## MMC St. John Employee Garage - LIII Site Plan Conditions of Approval Submittal for Issuance of Building Permit

As discussed this morning, we have uploaded files onto the City's e-Plan site (into the folder entitled "Approved Plans Pending Conditions") to address the open conditions of approval associated with obtaining a Building Permit. This follows on the heels of the Building Permit application, which was submitted by the project team on Friday. Please see the red text below to clarify how each item is addressed by means of the uploaded files:

### B. DEVELOPMENT REVIEW

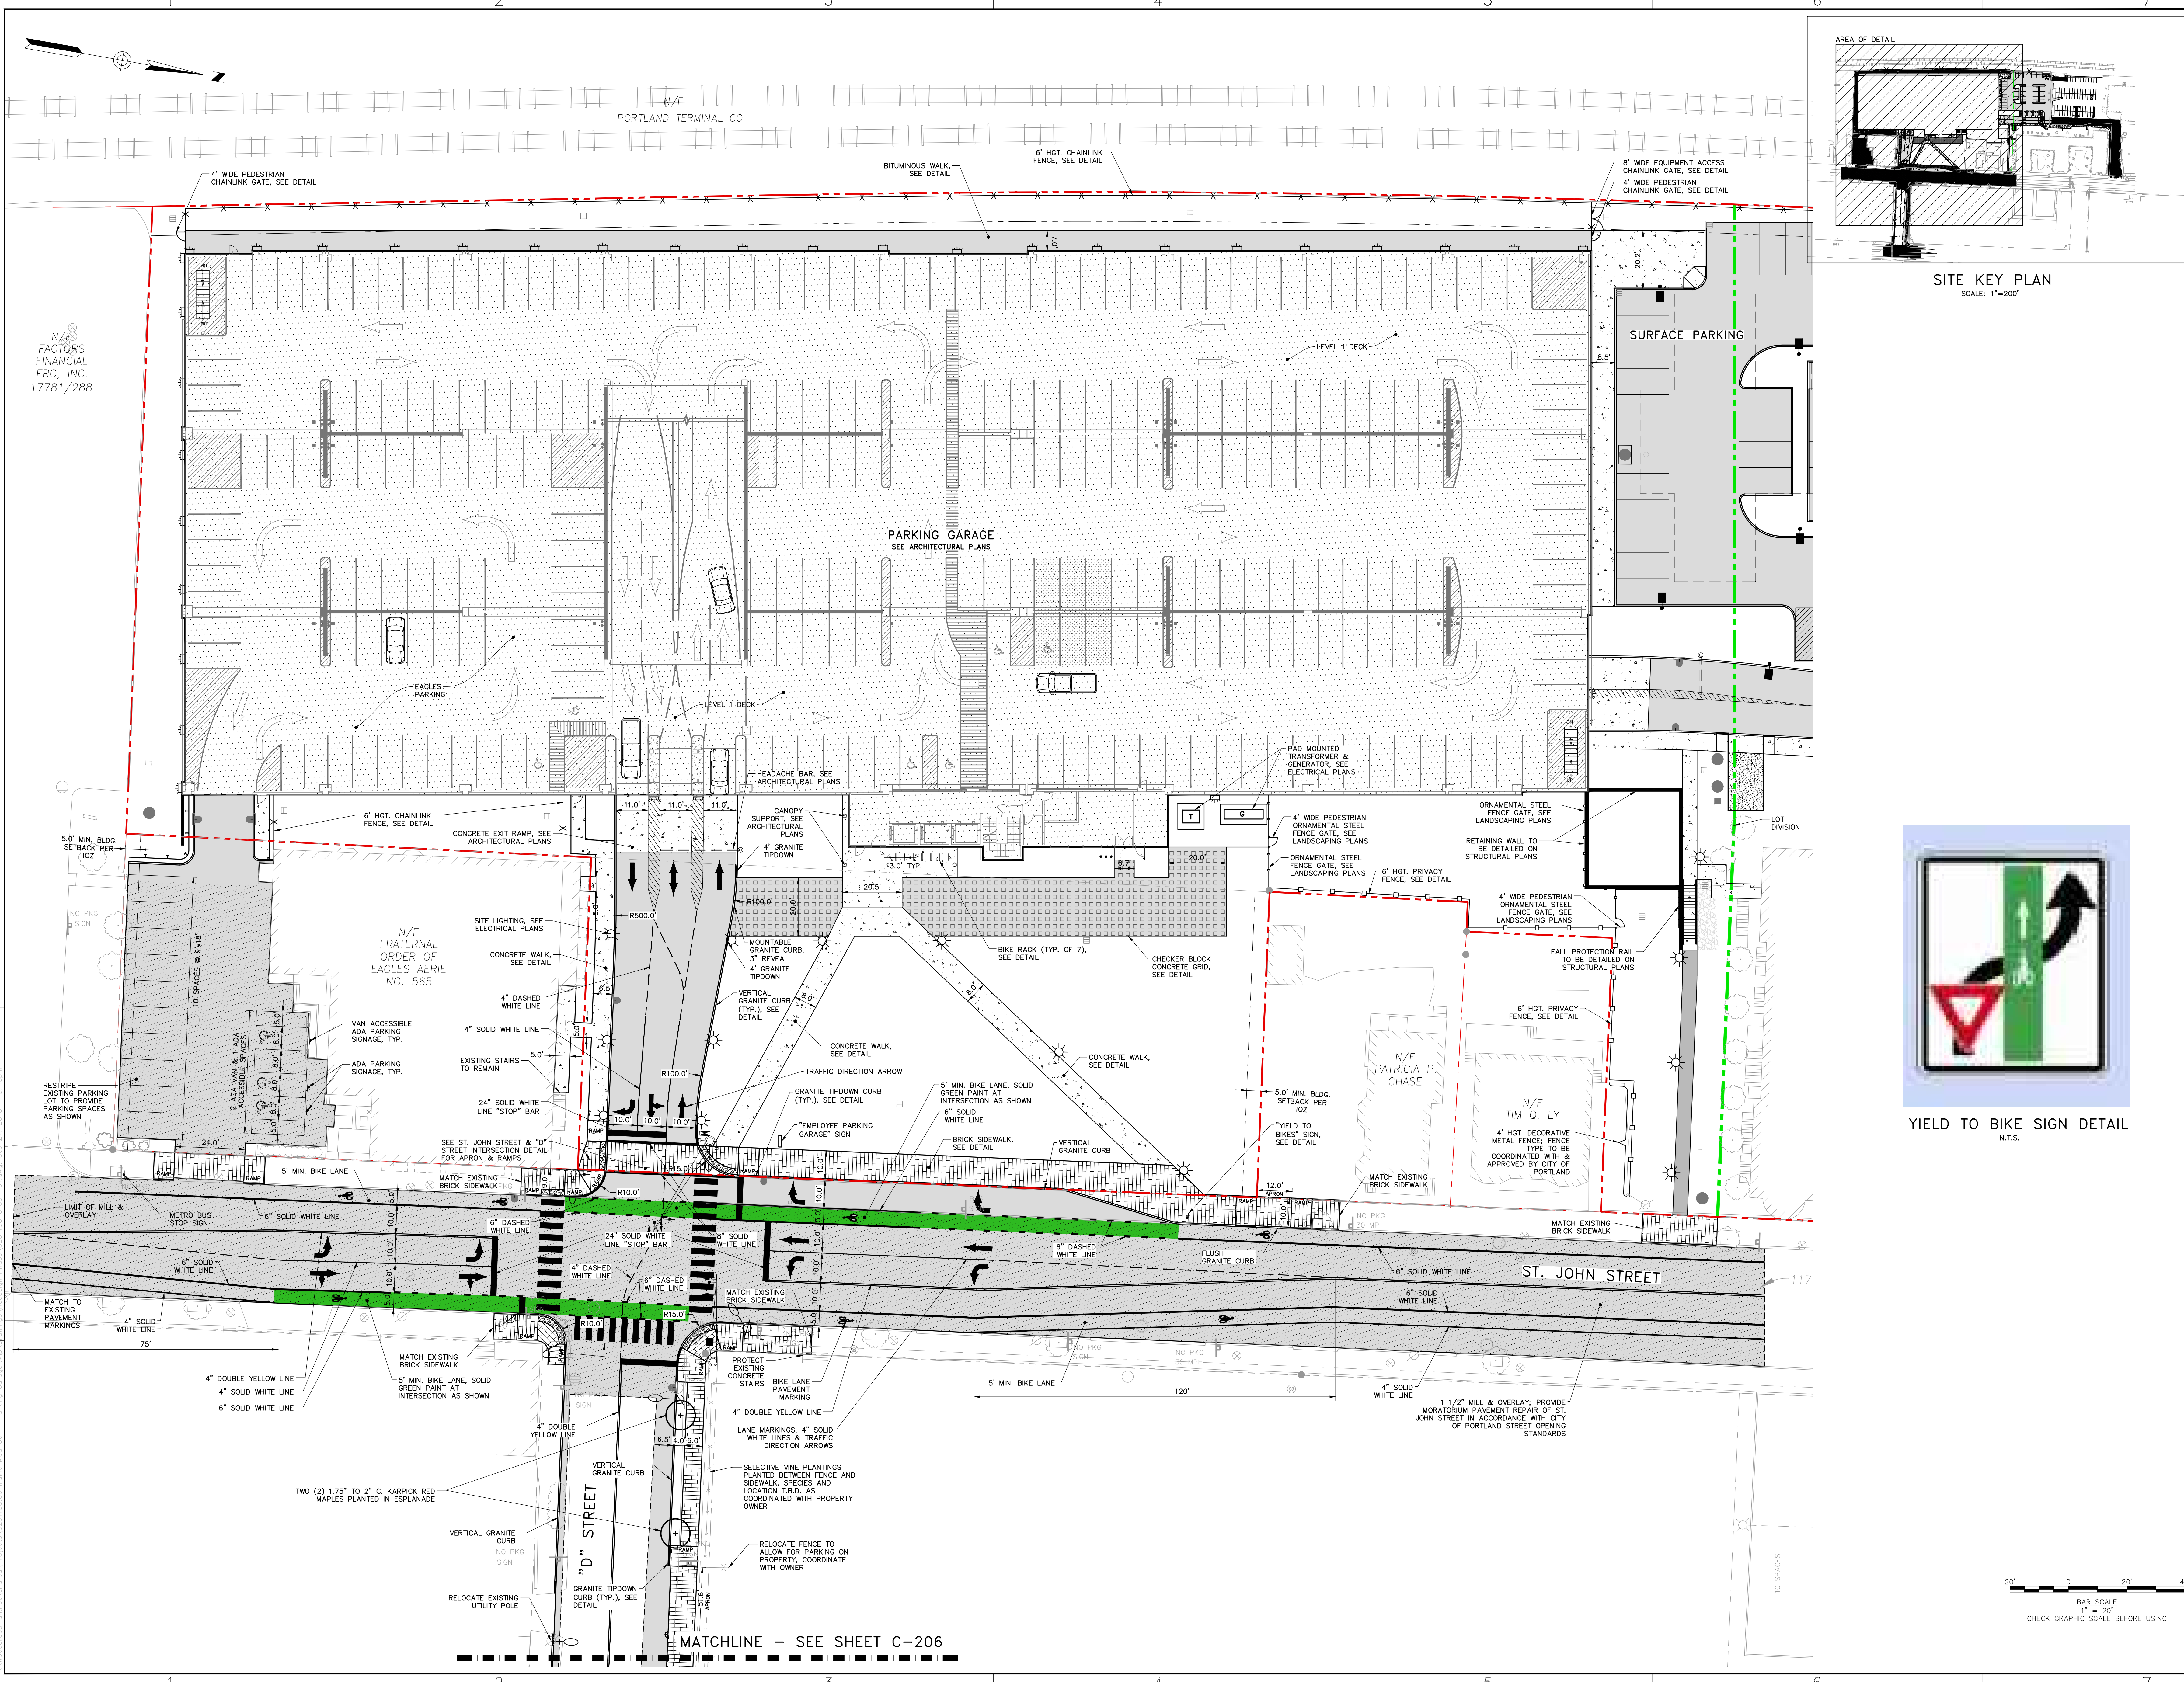
3. The applicant shall submit a revised site plan including: please see uploaded "MMC Civil Permit Set" for final site plans
  - i. Revised striping around the refuge island on Valley Street; addressed in uploaded plans

- ii. Revised bike lane pavement markings on St. John Street; addressed in uploaded plans
  - iii. "Yield to Bikes" sign; addressed in uploaded plans; note that image of the sign is shown on the site plan, as this particular sign does not have an established MUTCD code

- iv. Modified label for CB30 on D Street to not obscure the light fixture; addressed in uploaded plans
  - v. revised design of the curb ramp on the SW corner of St. John at the garage driveway to eliminate the skewed area with the vertical curb next to the ramp flares between the curb ramps; and addressed in uploaded plans

GRADING & DRAINAGE PLAN - 2

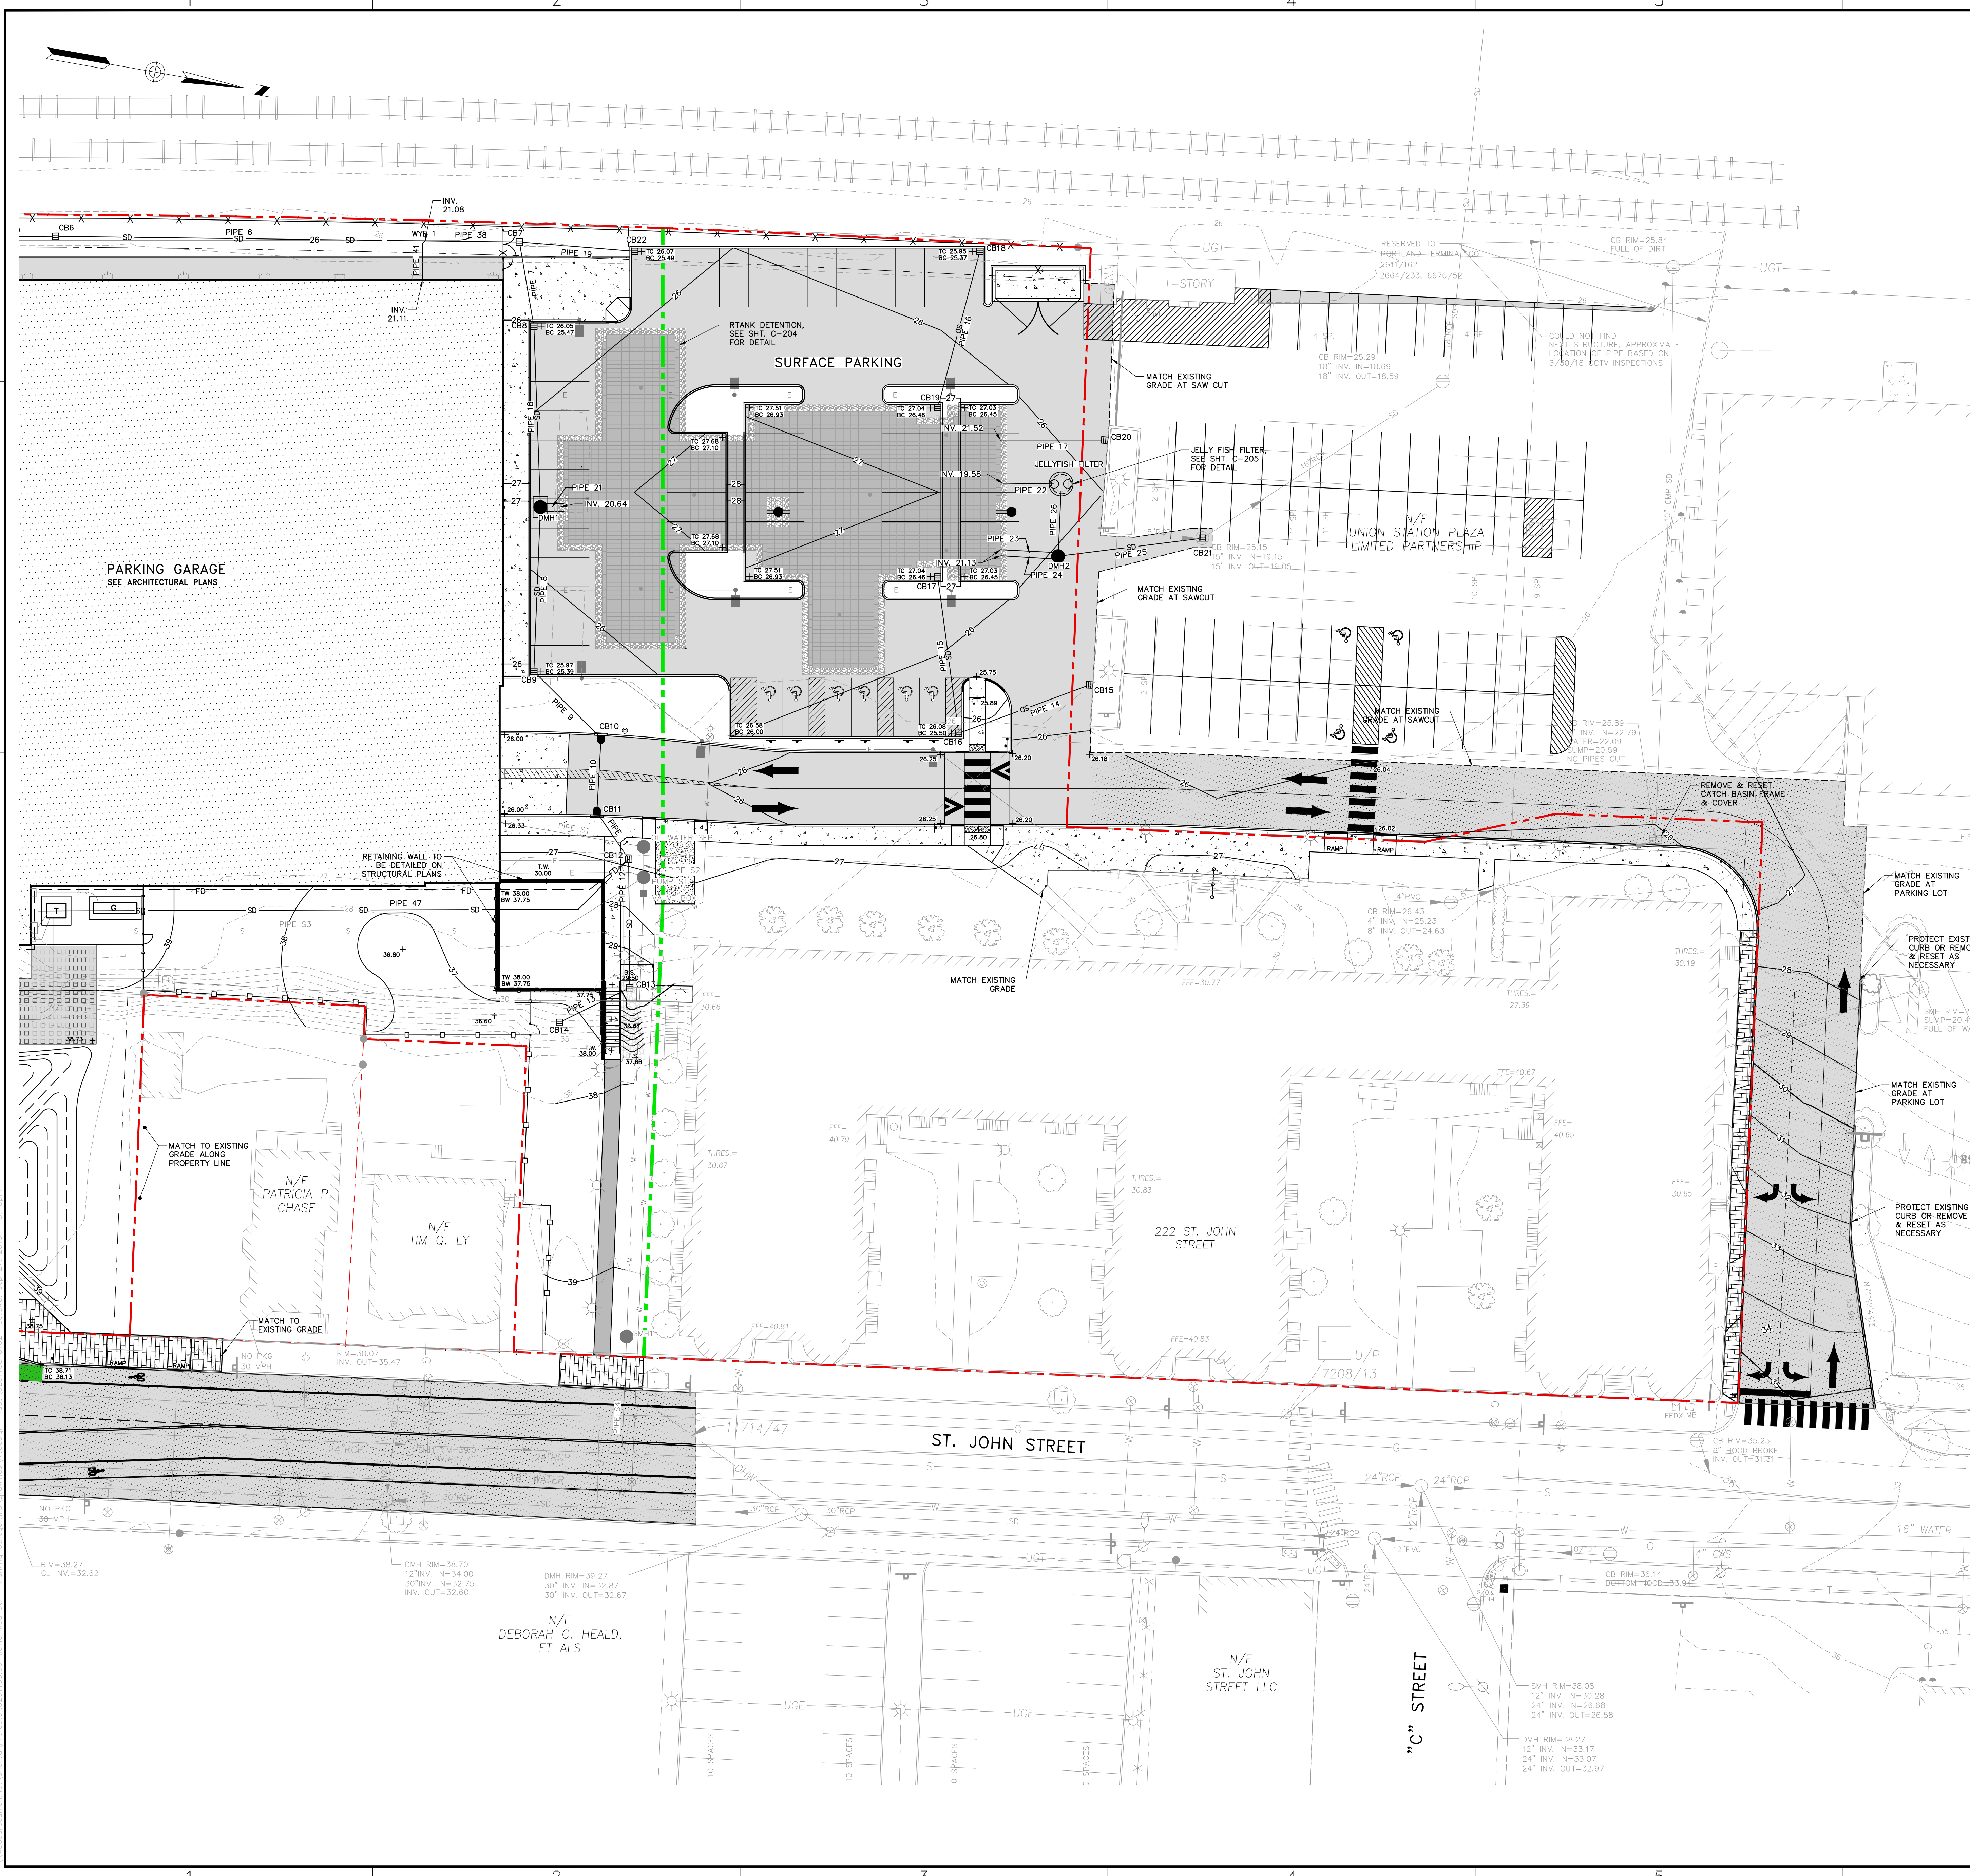
- ii. Revised plans addressing slope inconsistencies on Pipe 14; addressed in uploaded plans
  - iii. Revised plans showing a drainage from the elevator pit into an oil/water separator prior to entering the storm drain system for review and approval by the Department of Public Works. elevators will not have hydraulic systems; elevators are electric traction style, specification and cut sheet uploaded
